### **Durham County Council reference number: 20032071**

### **Durham County Council's Response to Examination Document PDL-013**

Route Alignment
 — Route Alignment
 — Order Limits
 - - - 200m Operational Air Quality Study Area
 — Affected Road Network (ARN)
 — Pollution Climate Mapping (PCM) Road Link (2019)

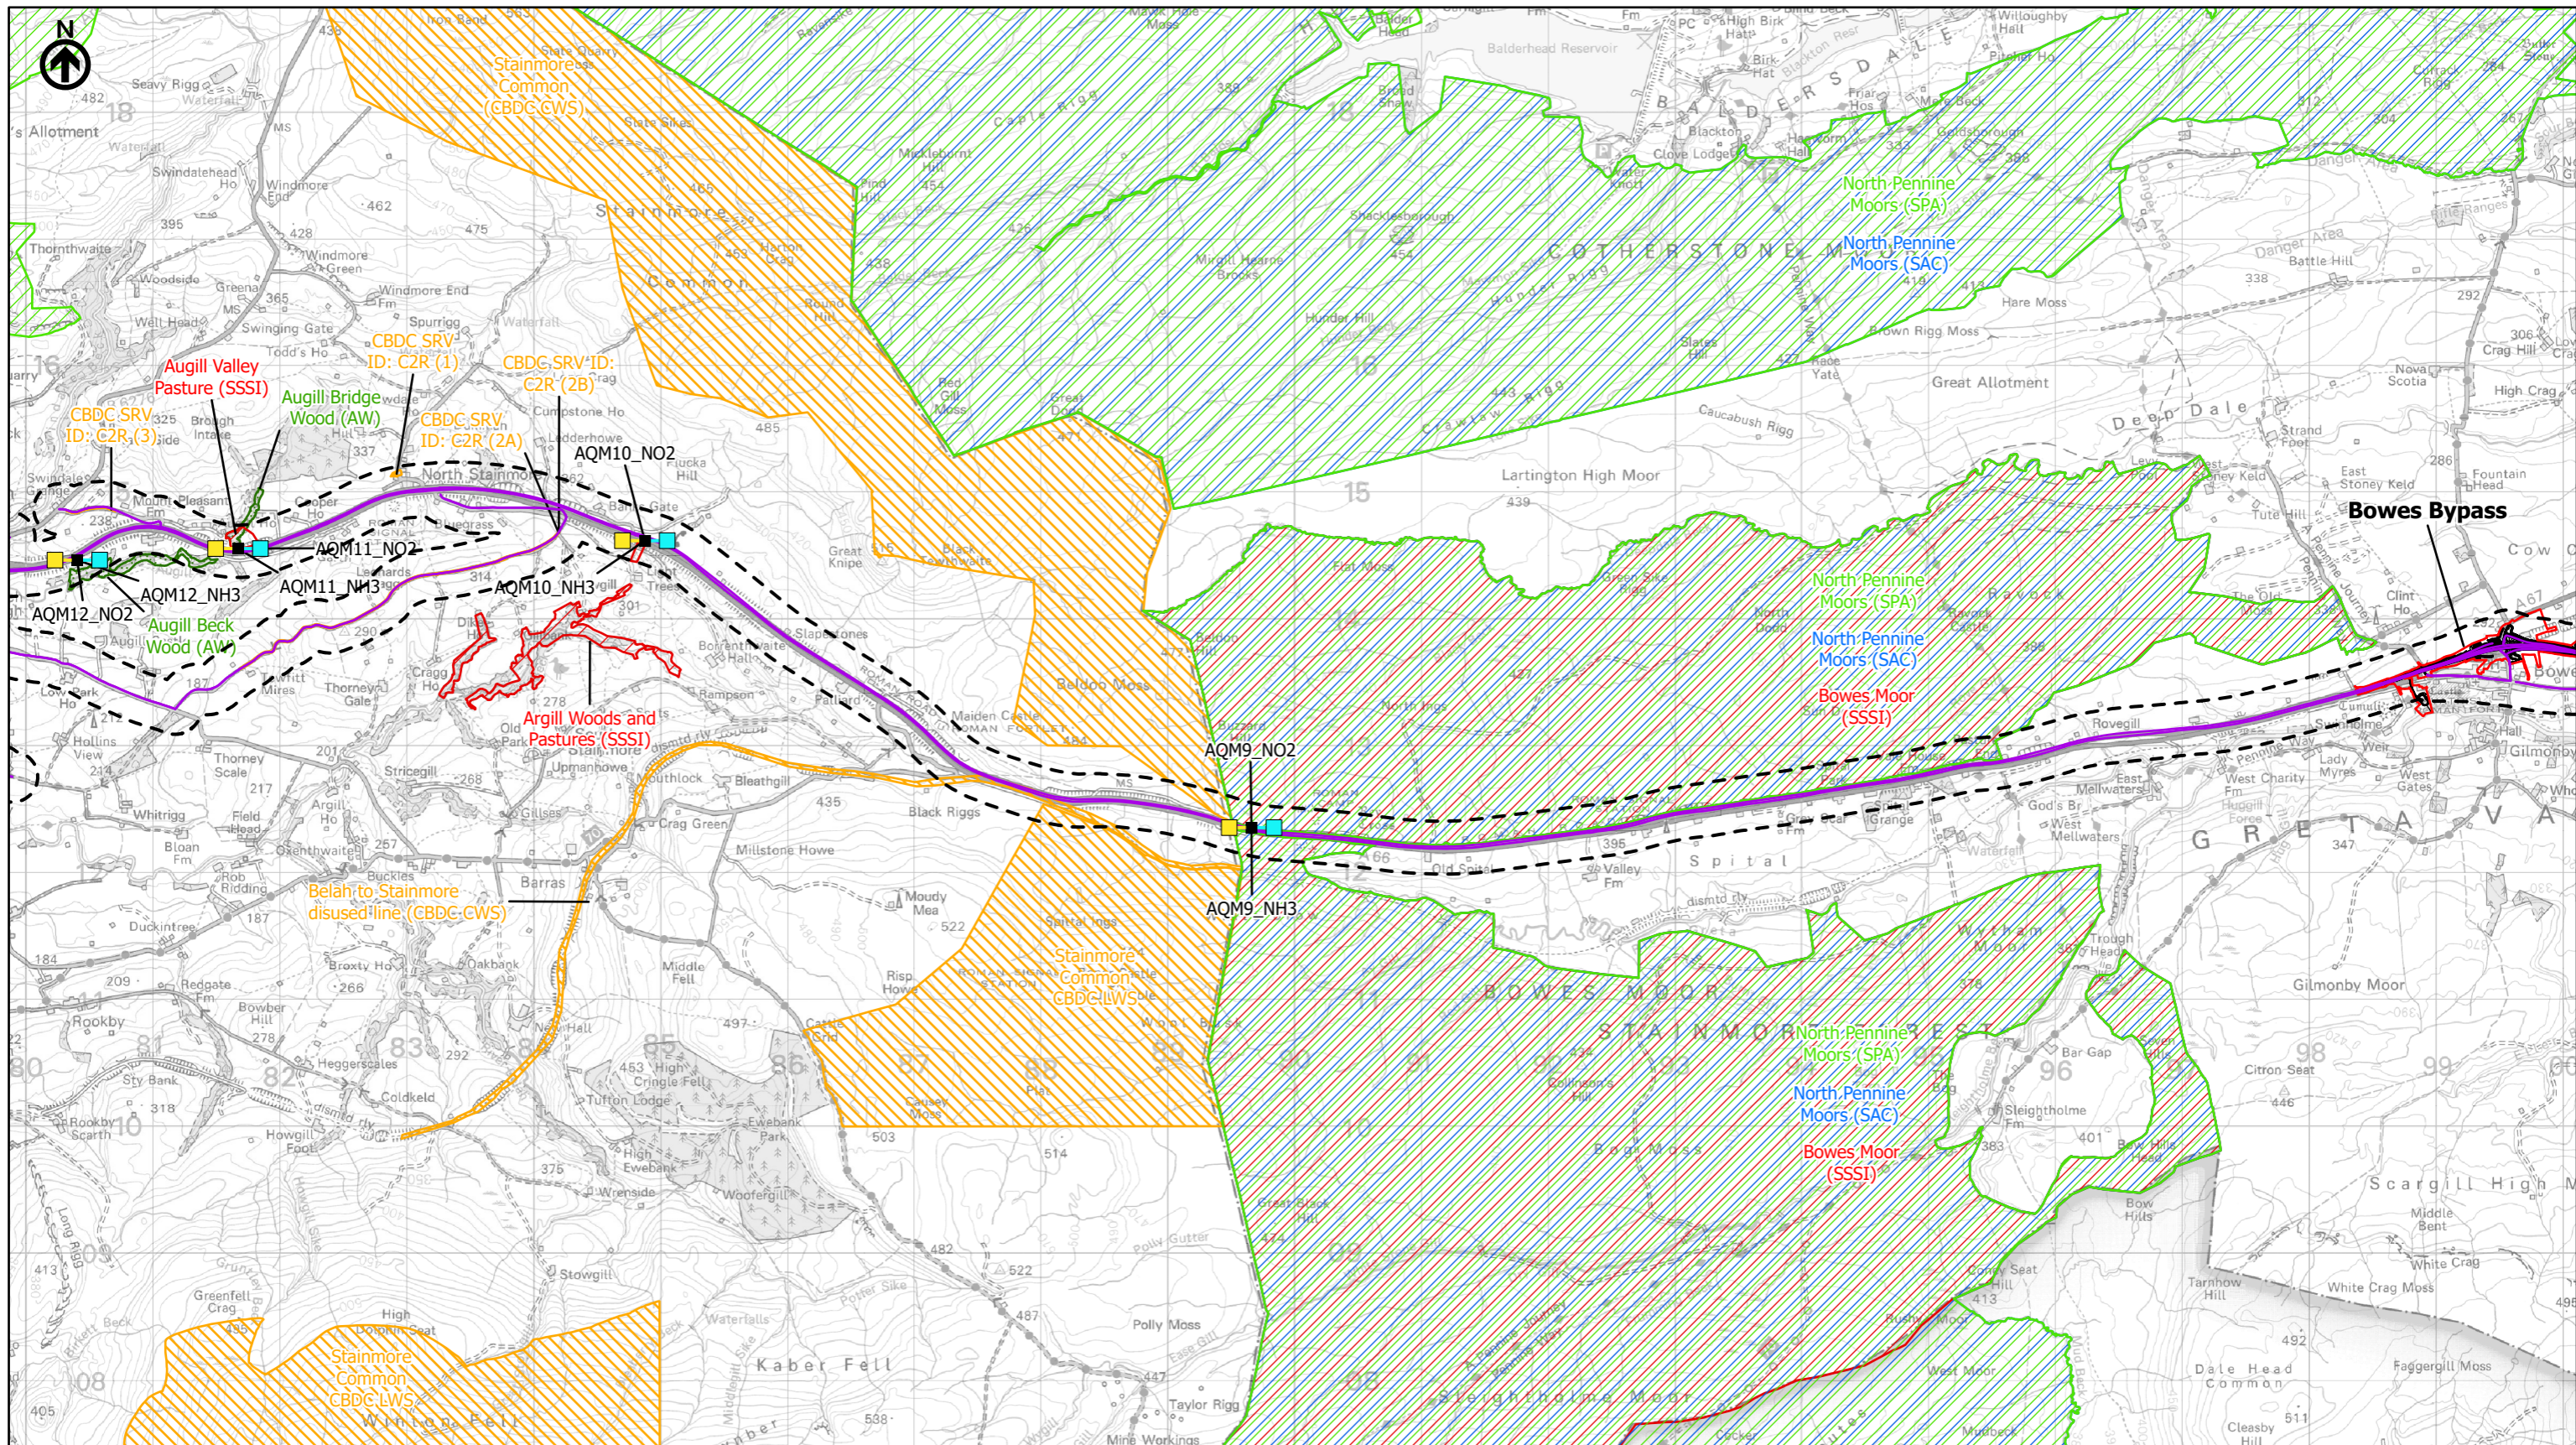
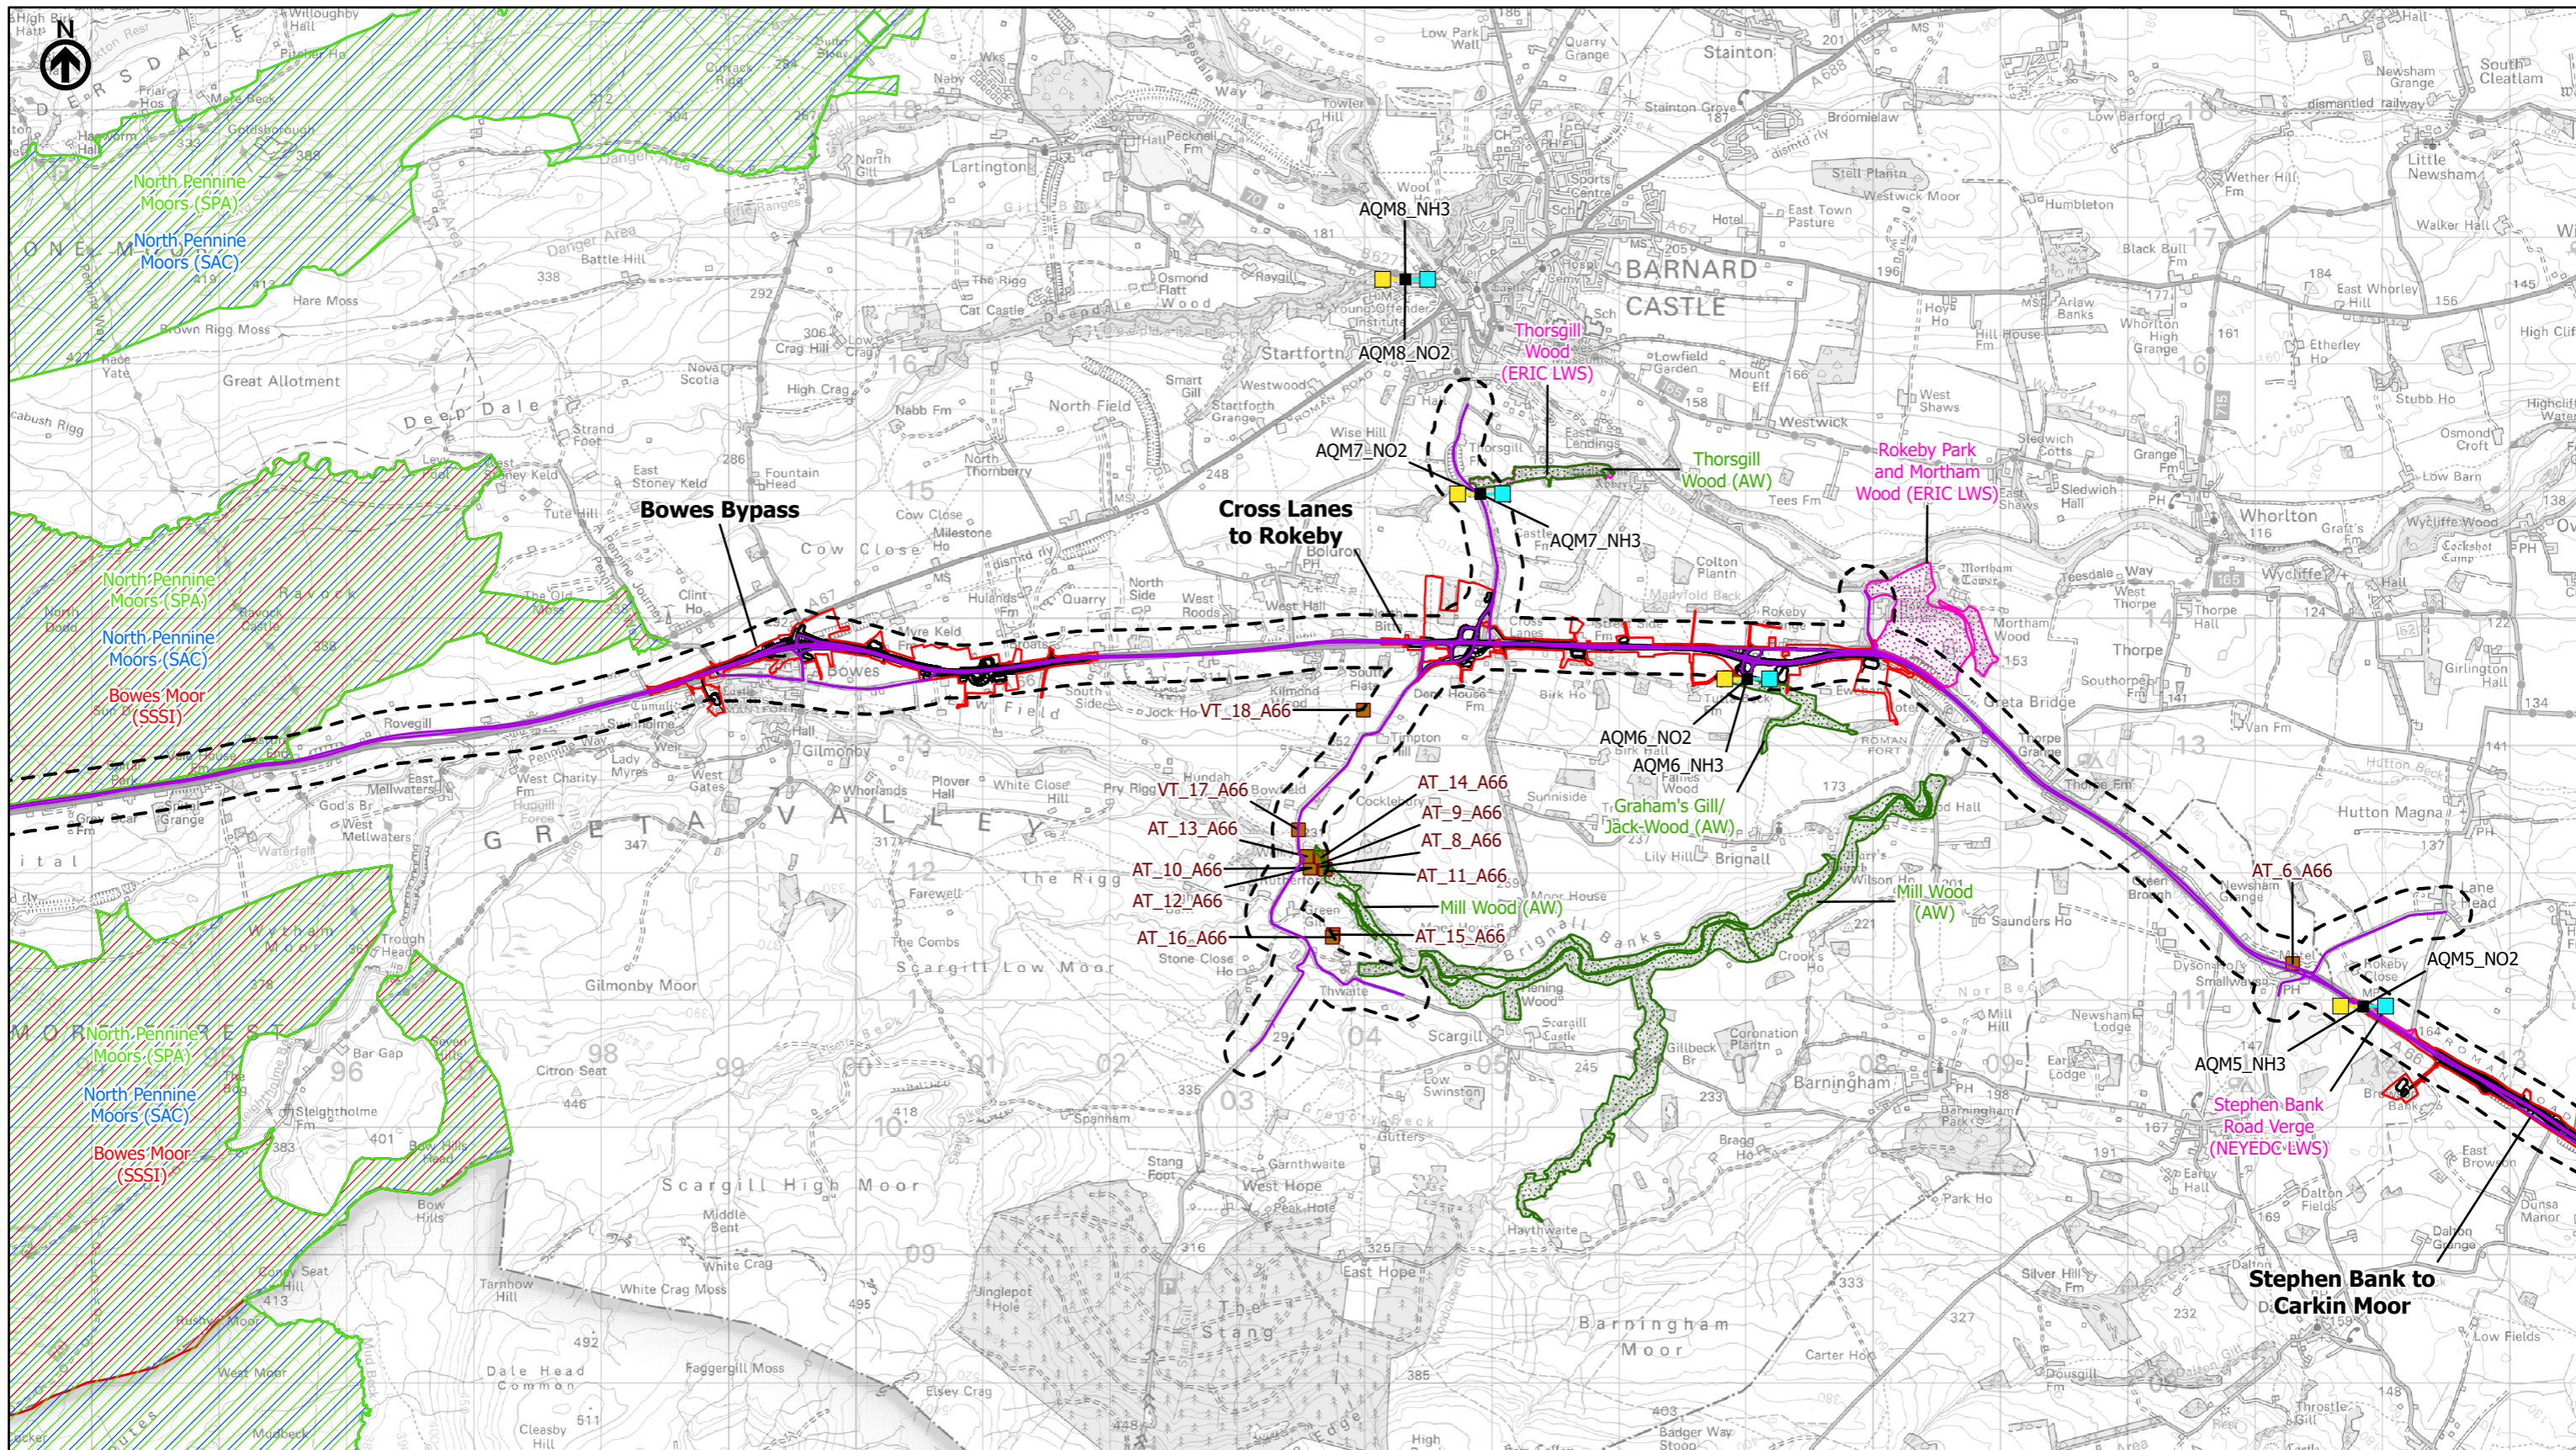
DCC response 31.08.2022	Applicant response 16.11.2022	DCC response 24.11.2022
Baseline		
<p>Baseline NO2, PM10 and PM2.5 have been presented in Appendix 5.3 Air Quality Baseline Monitoring. No Scheme specific PM10 or PM2.5 monitoring has been undertaken and it is noted that there is no nearby existing PM10 or PM2.5 monitoring in the study area within DCC. These three pollutants have been assessed for both construction and operational phases.</p>	<p>Preamble, no response necessary.</p>	<p>No further comment.</p>
<p>DCC air quality baseline has not been reported specifically to inform the baseline appreciation however considering the distance to the DCC air quality monitoring locations, this is not considered a material issue.</p>	<p>Duly noted.</p>	<p>No further comment.</p>
<p>Four months of NO2 monitoring was undertaken for the Scheme between November 2021 to February 2022 at 16 NO2 locations in triplicate; four of these locations were in DCC (AQM 5, 6, 7 and 8). DCC were not consulted on the locations or given the opportunity to provide insightful, local feedback on the locations where monitoring would be useful. Based on the level of impact indicated by document 3.7 Transport Assessment in both construction and operational phases, it would have been useful to monitor at a sensitive receptor location along the A67 in Barnard Castle, near the river bridge, where a number of dwellings are located at locations nearby the road edge.</p>	<p>The NO2 monitoring locations were informed by the findings of the Preliminary Environmental Information Report (PEIR) and were undertaken at locations where the preliminary assessment identified the likelihood of significant effects. The comments provided, relating to monitoring locations in Barnard Castle, are noted.</p>	<p>We have outstanding concern of potential air quality impact at sensitive receptors in Barnard Castle due to lack of project monitoring data. Monitoring data in Barnard Castle would be helpful to understand the air quality impact risk and assist inform key method points the assessment has taken.</p>

<p>There is no source of background nitrogen deposition rates used in the assessment provided in Appendix 5.3 Air Quality Baseline Monitoring. As per LA 105, this should be included in any reporting.</p>	<p>Background nitrogen deposition rates for the ecological sites identified in the assessment were taken from Air Quality Information System (APIS) at the time of ES drafting and assessment, as set out in Chapter 5 Air Quality (Document Reference 3.2, APP- 048) (Current Baseline - paragraph 5.7.3).</p>	<p>No further comment.</p>
<p>Defra annual mean background pollutants concentrations have been used in the assessment for 2019 and future year 2029; in grid square contribution from major road sector emissions have been removed from the background NOx estimates. This is reasonable. A comparison between Defra modelled and local authority background NO2 monitoring data has been made; this showed that Defra backgrounds were slightly lower than local authority monitored data however there is no discussion on this other than the difference is small (1 µg/m<sup>3</sup>) and concentrations are below the objective, nor any consideration discussed of factoring the Defra predictions using the monitoring. Given the low levels of predicted model result concentrations, this will not likely materially affect the conclusions.</p>	<p>Reviewer statement, no response required.</p>	<p>There are a number of methodological assumptions in the assessment that we consider not to represent a reasonable worst case. Therefore, it is not clear whether reasonable worst-case assumptions would materially affect the conclusions of the assessment.</p> <p>An assessment taking into account a reasonable worst case here would have used the monitoring data to inform the background pollutant concentrations.</p>

<p><b>No DCC monitoring or National Highways monitoring within DCC boundaries has been used to verify the model outputs against measured data. It is further understood that none of the Scheme-specific monitoring has been used for verification. Discussion would be useful in this instance to present how representative the verification is of receptors within DCC.</b></p> <p><i>At this point it has been assumed that the applicant's numbering system has been disrupted and is incorrect. Comments have therefore been addressed from this point on, on this basis.</i></p>	<p>12 and 13. There are no DCC monitoring locations adjacent to the ARN (as noted by the Interested Party in comment (2) above which they acknowledge is not a material issue). Available data from a National Highways air quality monitoring station have been used for model verification. Several administrative areas are covered by the assessment study area which is predominantly rural in nature with pockets of urban settlements; overall, air quality is good. In addition to National Highways air quality monitoring data, the model was verified using local authority monitoring data from representative roadside locations adjacent to the ARN. As noted above in response to item (13), site typology was considered and two separate verification factors, one for urban and another for rural road links (and receptors), were derived and applied. Where possible, sites with ≥75% data capture were used; where this condition could not be met, in one instance, this has been noted. The verification using the rural zone for use</p>	<p>A reasonable worst-case and robust assessment should be undertaken. It is not considered a reasonable worst case to use an adjustment factor lower than 1 to adjust any dispersion model outputs, given the ADMS software's tendency to underpredict. Relying on an RMSE of 12.6ug/m<sup>3</sup> is not considered robust, based on the guidance referenced in the ES chapter, and it is recommended that the modelling and verification that informed the assessment of construction and operational phase impacts is revisited. It is also not considered a limitation of the assessment to not use more monitoring data locations. Should DCC not monitor in this area, project specific monitoring should have been</p>
